CUMBERLAND
CITY COUNCIL

Our Ref: OA2022/0006

Subject: Request for Comments - State Significant Development (SSD)
Application No: SSD-10399-Mod-4
Property: 44 Clunies Ross Street & 615A Great Western Highway, Prospect & Lot 107 Clunies Ross Street, Pemulwuy NSW 2145
Proposal: Changes to the built form, warehouse layout and number of car spaces associated with the approved Warehouse 1 and proposed signage

Project: P1227 Prospect Logistics
Drawing Title: Warehouse 3 26m B-Double

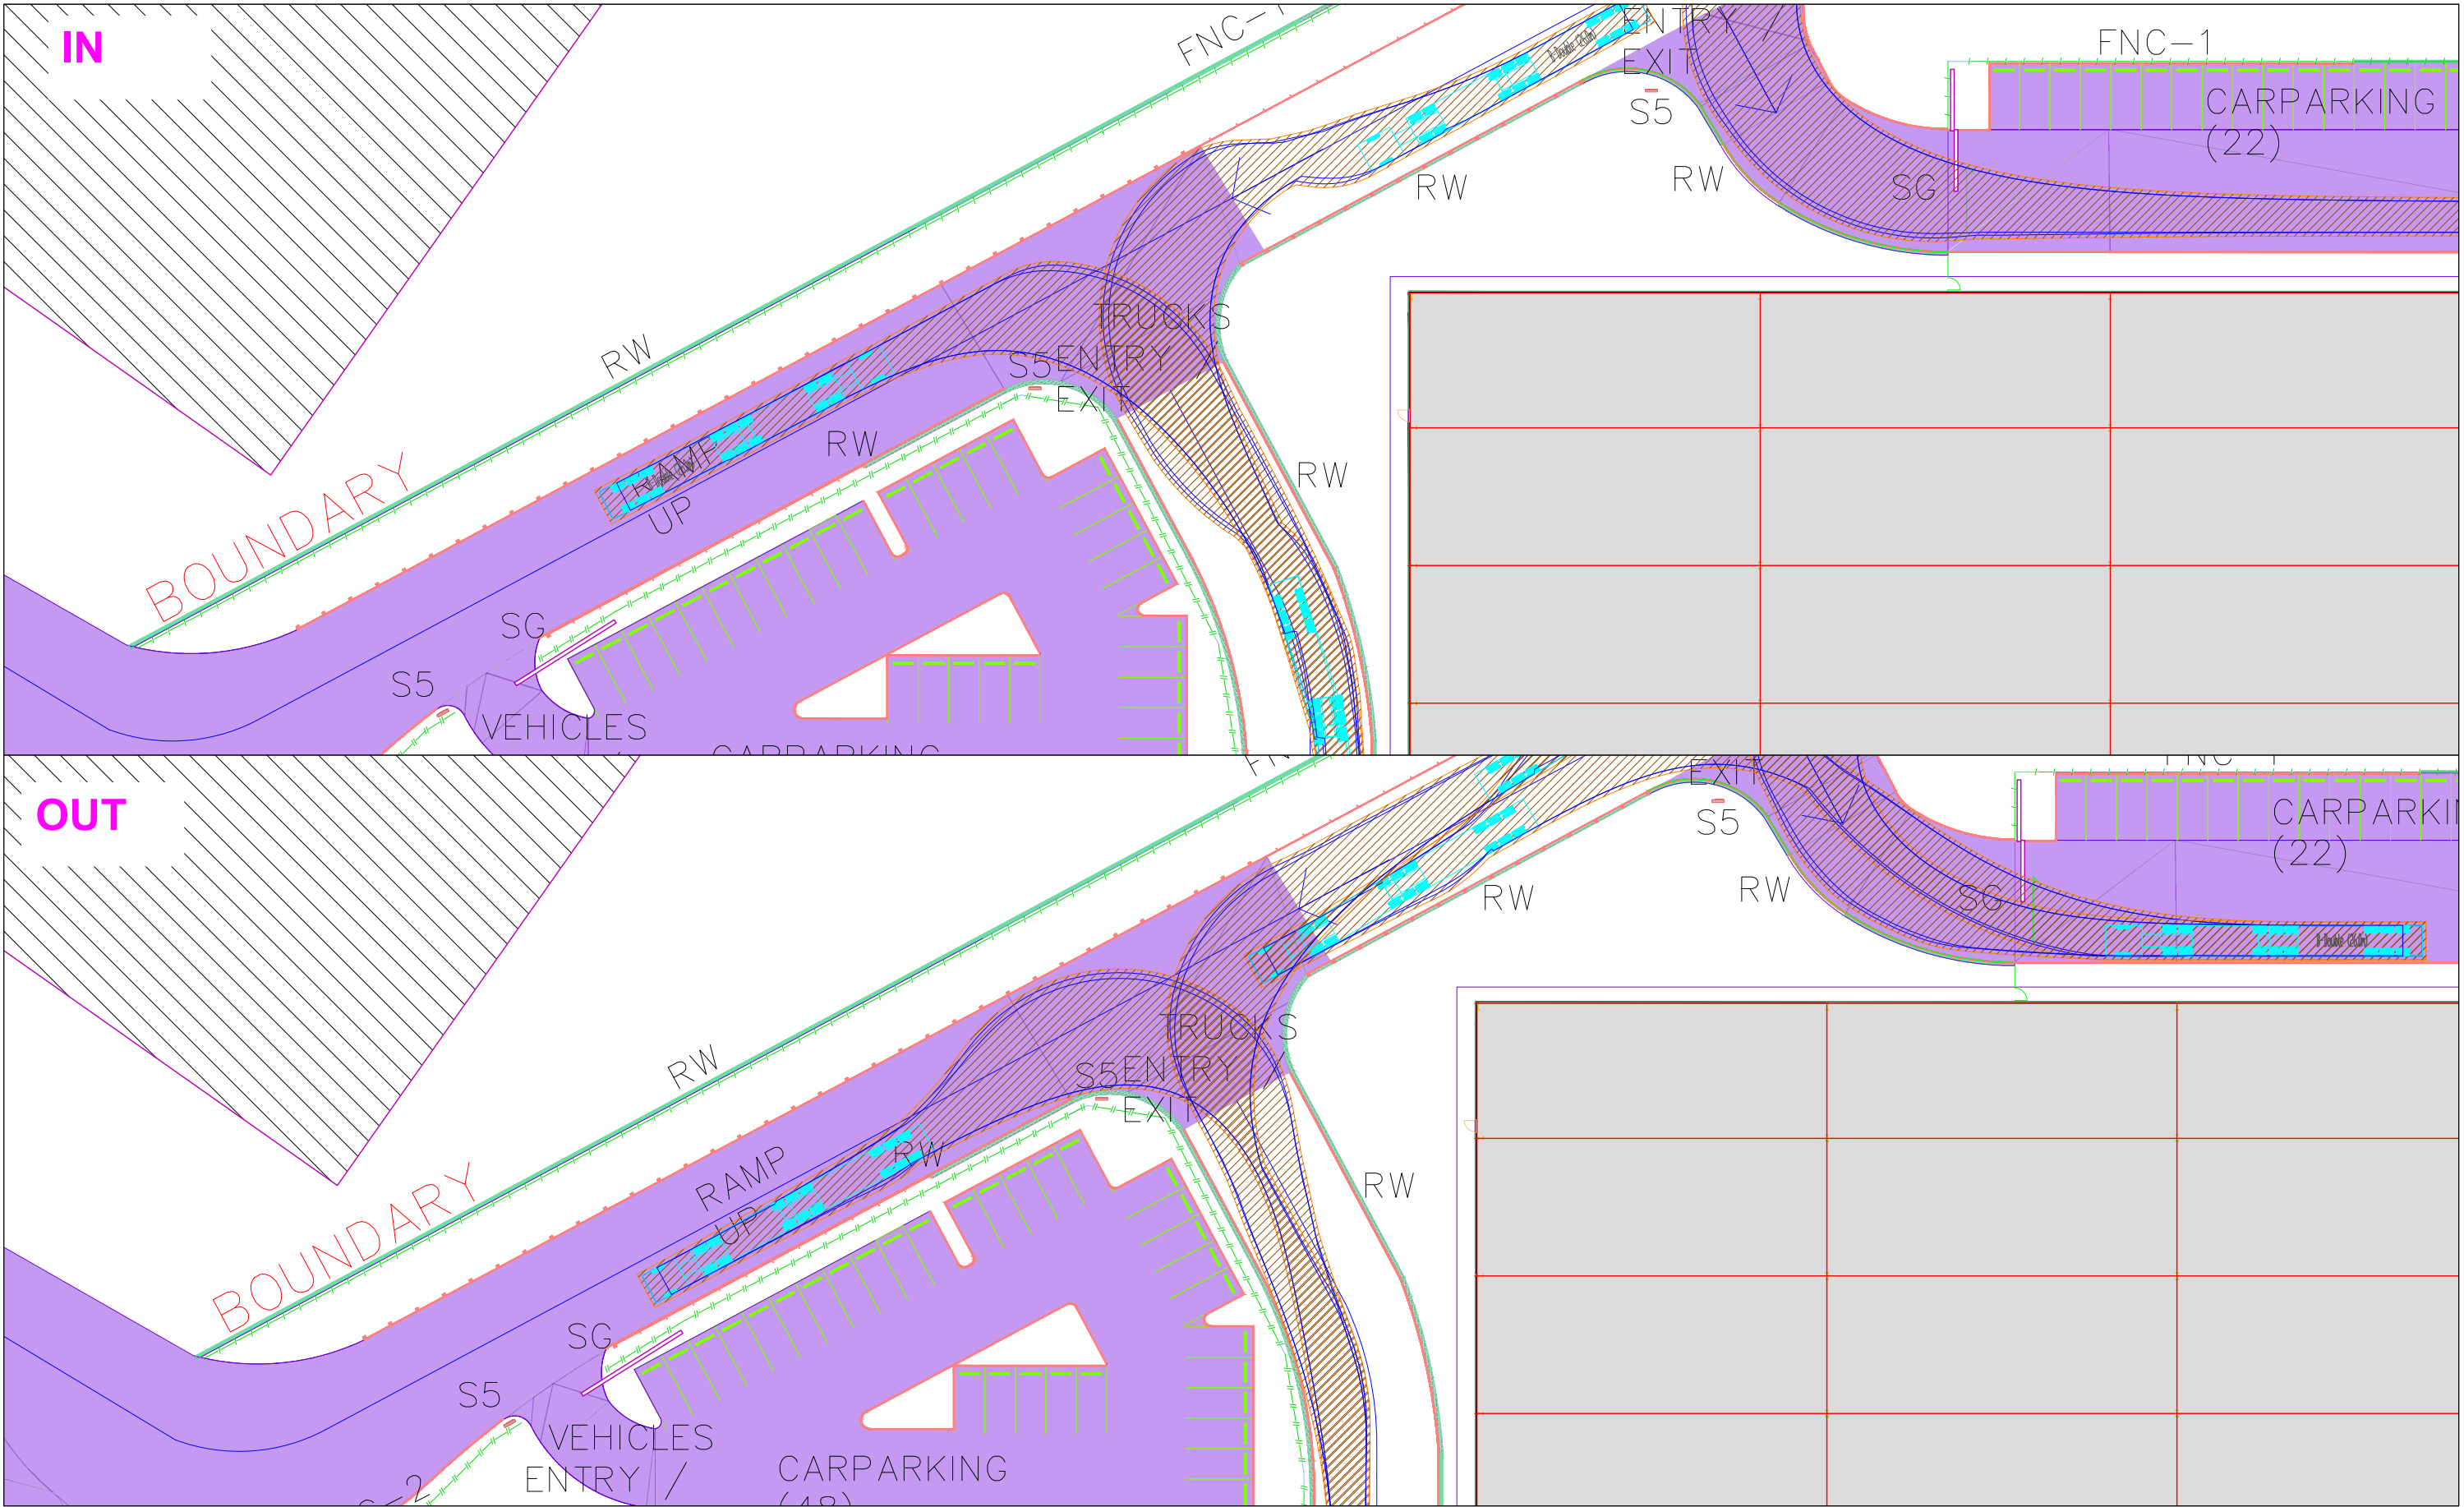
1. It should be noted that B-Double route is not available in Foundation Place as per the Transport for NSW information. Clarification in relation to this matter is required prior to the determination of this application.
